MEMORANDUM

TO: City of Portland – Planning Board
FROM: Jim D. Wentworth, P.E.
DATE : February 21st, 2018
SUBJECT: Maine Medical Center – Constructability Review

Kleinfelder was tasked by the City of Portland’s Planning Department to assist in the constructability review for the vertical expansion of Maine Medical Center’s existing visitors parking garage.

**Congress Street closure affects the following properties or entities:**

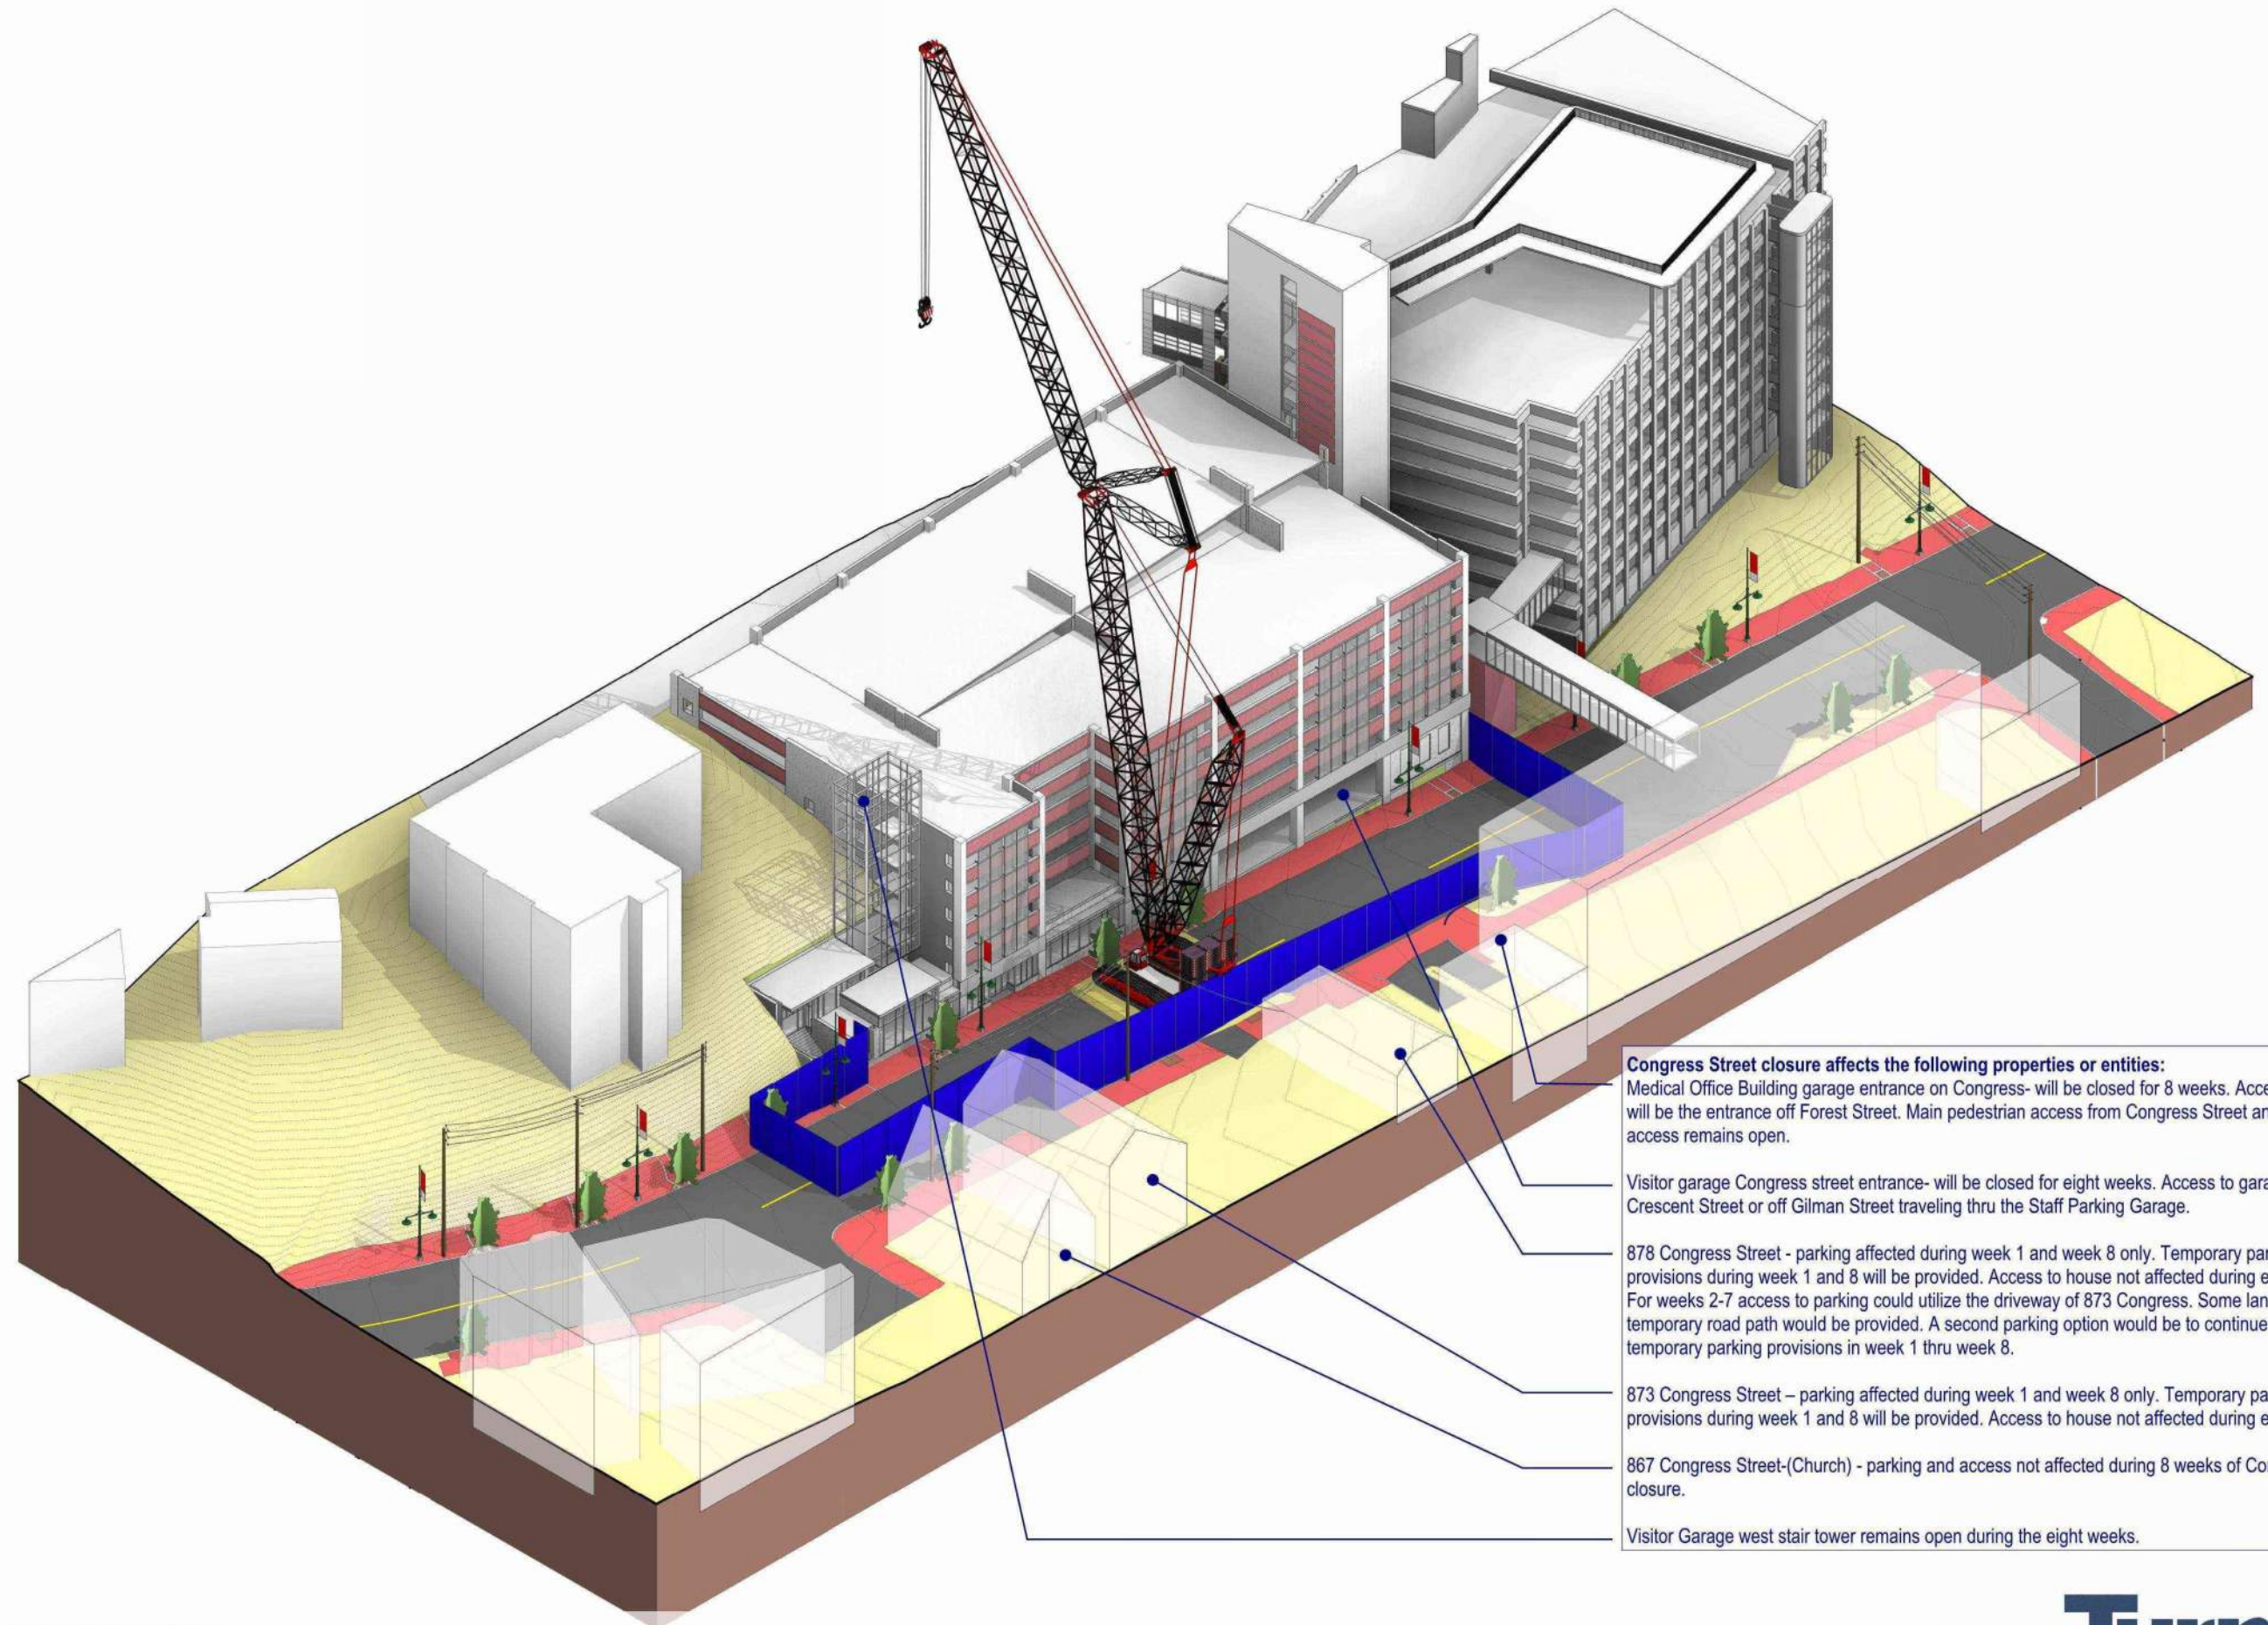
- Congress Street is approximately 43'9"± curb to curb based on cross section provided by Turner.
- The sidewalk abutting the visitor garage is approximately 10'6"± in width.
- The sidewalk on the North side of Congress is approximately 11' ±in width.
- The proposed 440 Ton Liebherr Crane is approximately 45 feet in length from front of track to back of counterweight. This crane configuration takes up the majority of the roadway and overhanging 2-3± feet of the sidewalk.
- The Main boom on the crane cannot operate totally vertical and will use all of the available 10'6"± sidewalk area to face the garage.
- There is no available *safe width* for emergency or passengers vehicles to travel through the area based on the crane operating parameters.
- There is limited available width (7-8 feet ±) for protected pedestrian traffic along the North sidewalk.

- This option has similar site and crane parameters as Option 3, but calls for a shutdown Congress Street for 8 weeks.
- The 440 T Liebherr crane configuration is needed to reach up and over existing parking garage for lifting and reach capacity reasons to install the 30 Ton precast Double tee beams.

- A mobile crane does not have the 30 Ton capacity to reach up and over the building.
- The 440 T Liebherr crane will have two sections of crane boom: Main Boom-161 feet, Jib-161 feet. (320 ± feet).

- A 300 foot length of Congress from pedestrian skybridge to Weymouth is necessary to assemble the crane along with its boom and jib.
- A single phase power utility line exists at corner of Congress and Weymouth which will not affect boom assembly.

- There is no additional street or sidewalk width with this crane configuration to safely use this option with emergency vehicular traffic.
- Delivery of the 85 foot long precast units for this option from Weymouth to Congress is feasible.

*Based on the information provided and reviewed, **Option 4 is recommended.***
